CITY OF ALBUQUERQUE

PLANNING DEPARTMENT – Development & Building Services

RE: **Palisades Subdivision, Replat of Block 4, Lots P-1, Q-1, R-1 # J11-D009**
5209 – 5219 La Bajada Drive NW (DRB Case # 10009710)
Conceptual Grading and Drainage Plan for RePlat PE Stamp: N/A

DRAINAGE PLAN FOR THE REPLAT OF
LOTS P-1, Q-1 & R-1
BLOCK 4 THE PALISADES

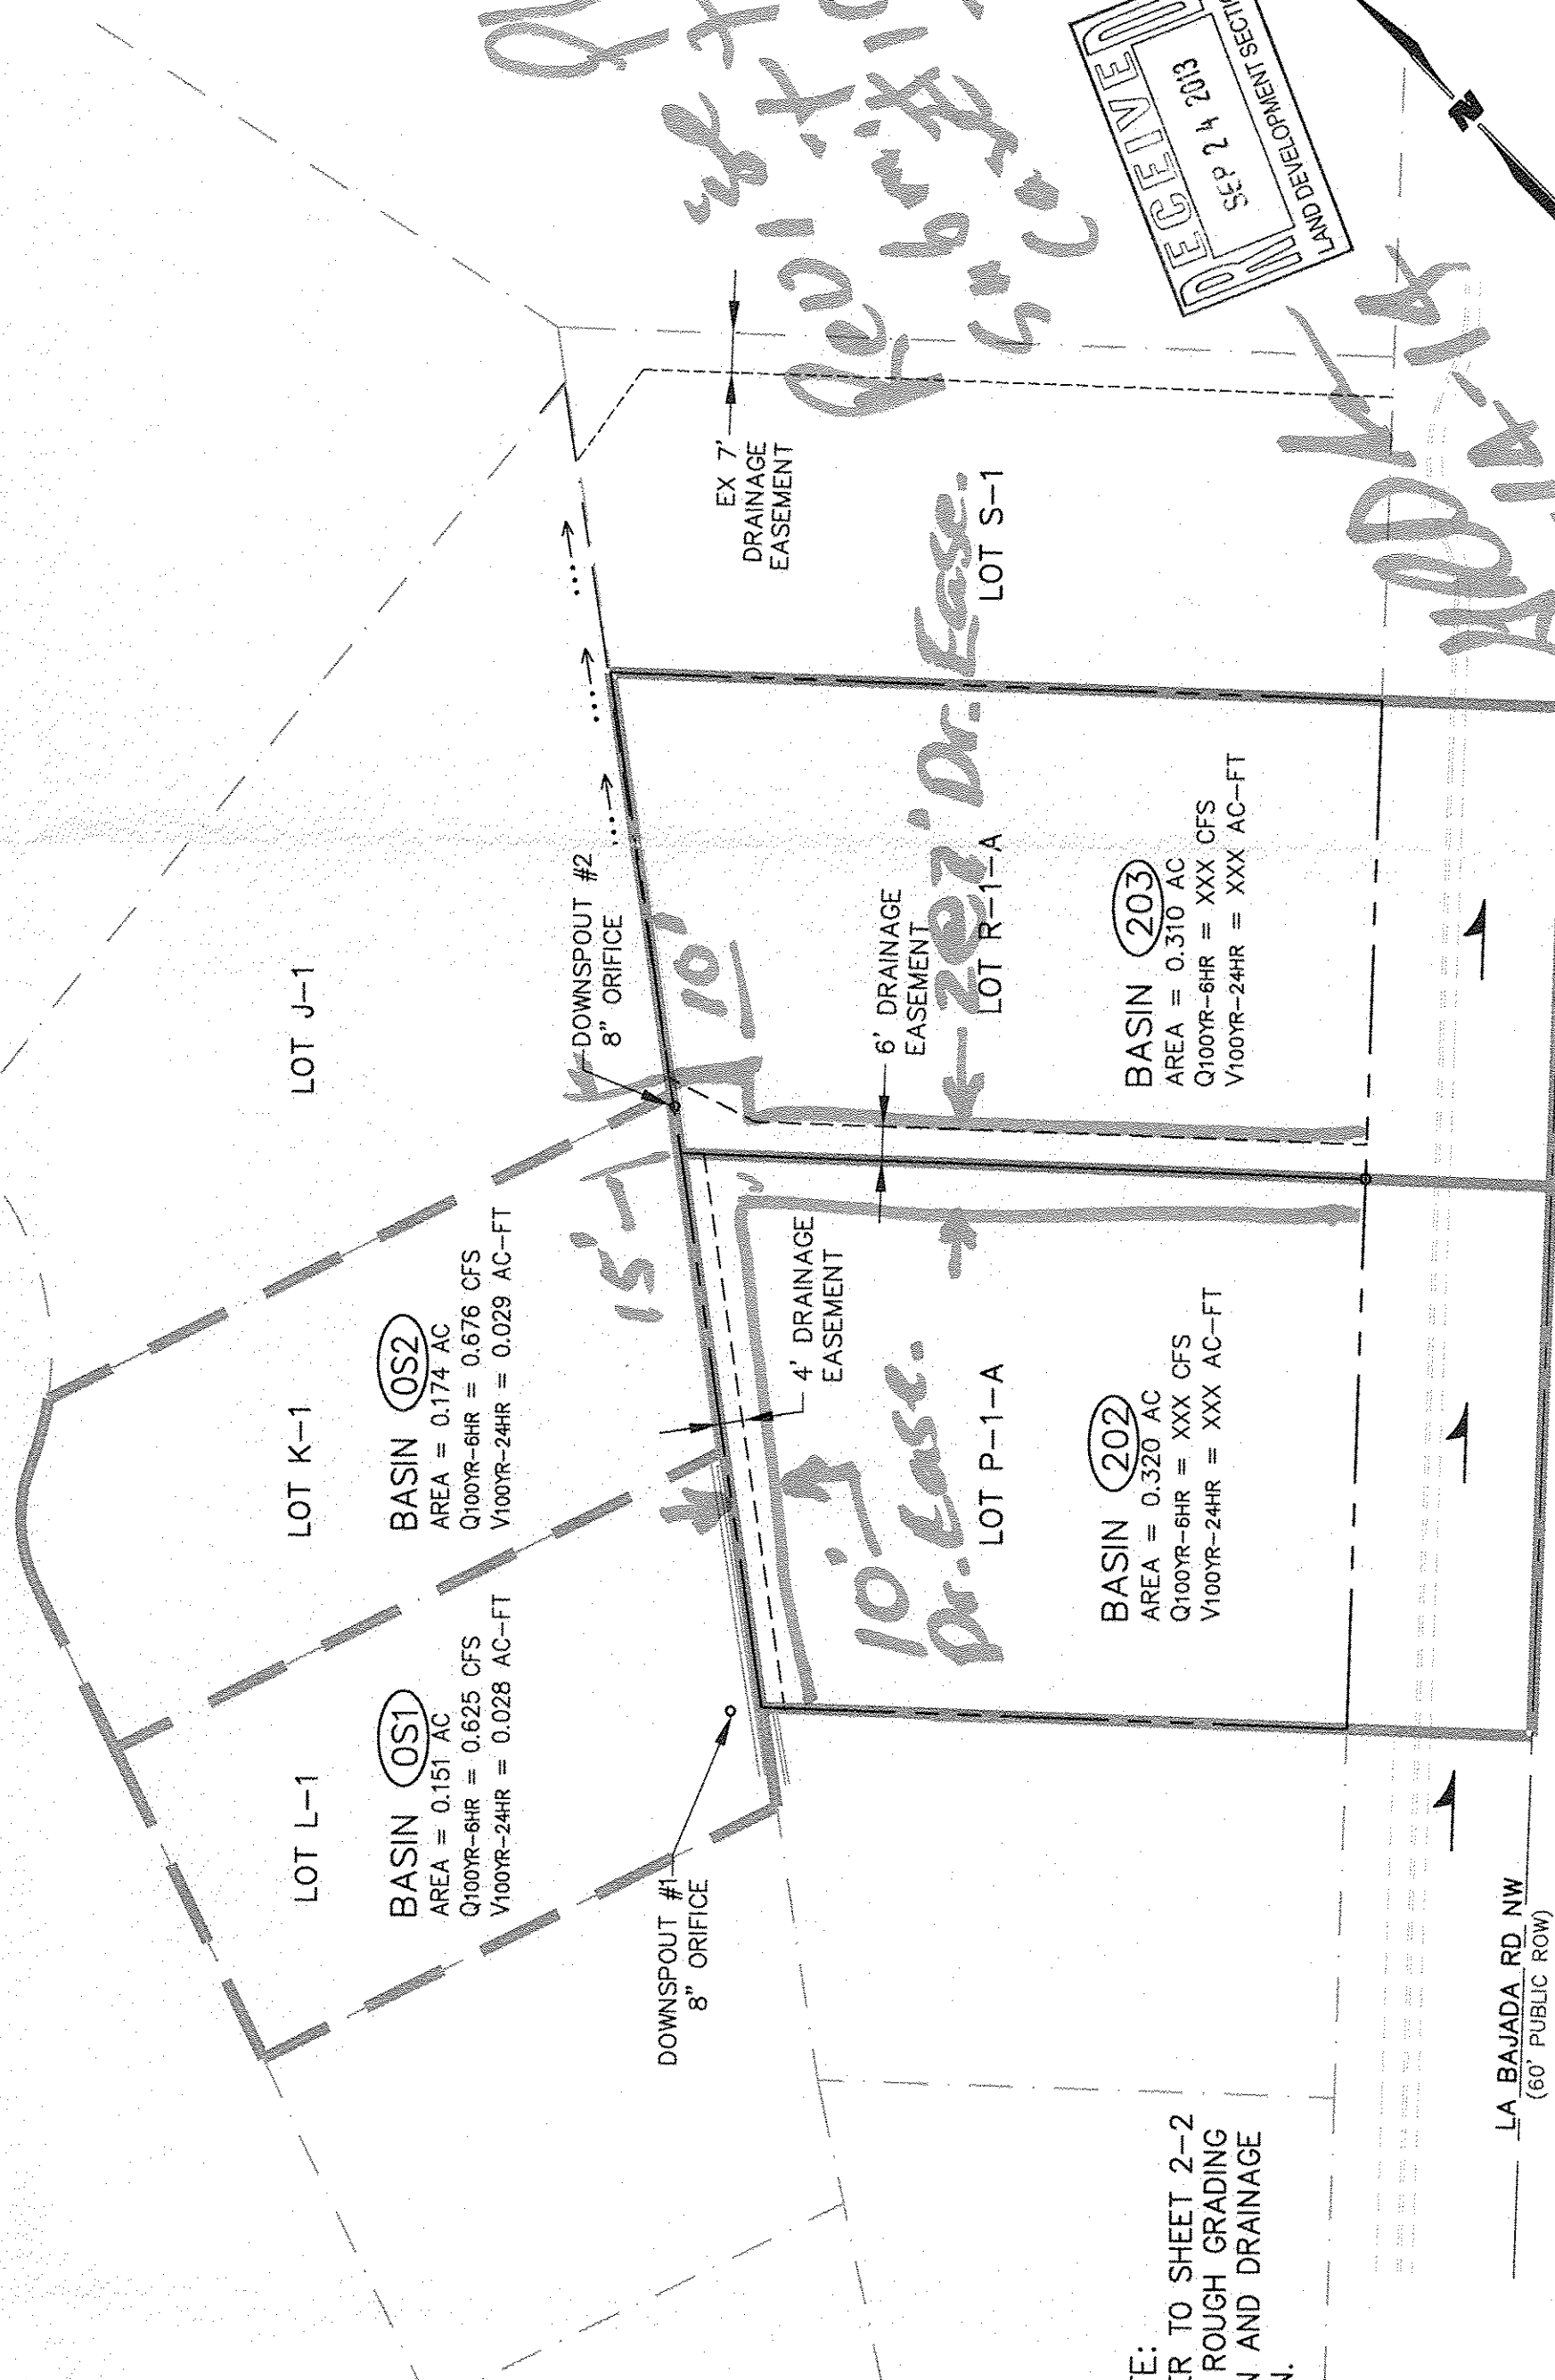
1. On proposed lot P-1-A, provide a 10-foot Drainage Easement along the back, NW side of the lot, and a 7-wide Drainage Easement along the, NE side of the lot, for the benefit of Lots L-1 and K-1, to drain to the La Bajada Road R/W.
2. On proposed lot R-1-A, provide a 10-foot wide by 15-foot long Drainage Easement at the back, SW corner of the lot, and a 7-wide Drainage Easement along the NE side of the lot, for the benefit of Lot K-1 to drain to La Bajada.
